**Lead Local Flood Authority**  
**Post Point CHN 215**  
**Hertfordshire County Council**  
**County Hall, Pegs Lane**  
**HERTFORD SG13 8DN**

Date 15 February 2021

**RE: 6/2021/0072/MAJ – Northaw House, Coopers Lane, Northaw, Potters Bar, EN6 4NG**

PROJECT No: 1-046 DRAWING No: 1-046-CCE-XX-XX-DR-C-001 REV: 1

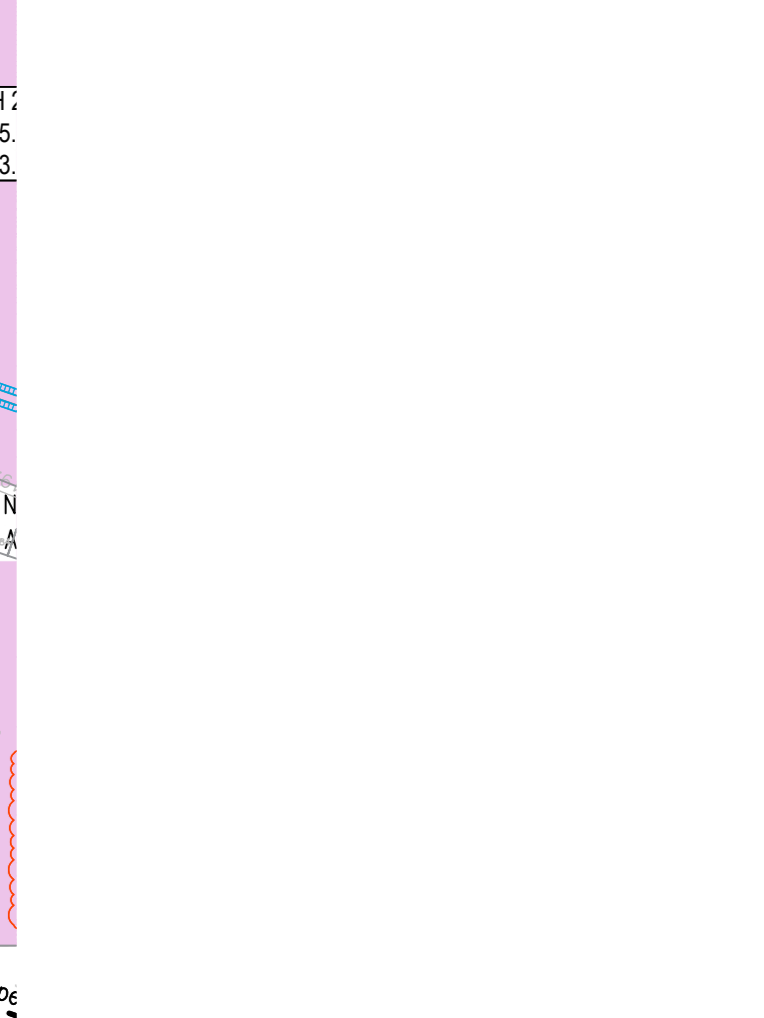
1. We understand several units are proposed in the east of the site labelled 28 ED – 31 ED and 19 GL, however these are not indicated on the drainage strategy and it is not indicated how these areas will drain on the drainage strategy.

2. We note the surface water pipe runs in the eastern road (pipes 12.000 – 12.001). Please could the applicant clarify how runoff from this part of the system will receive SuDS management and treatment before entering the pond.

Please could the applicant also clarify how the swale north of this eastern road connects to the wider drainage network to be discharged.

3. The applicant has provided calculations for the 1 in 100 year + 40% climate change event and confirms that the basin size has been increased to provide a total volume of 1305 m<sup>3</sup>. The applicant has provided post-development network calculations including half drain down times indicating the basin will take approximately 27.13 hours to drain down to half during the 1 in 100 year + 40% climate change event.

However, we require half drain down times to be less than 24 hours or evidence that the proposed network can manage for a 1 in 100 + 40% climate change storm followed by a 1 in 30 year event.
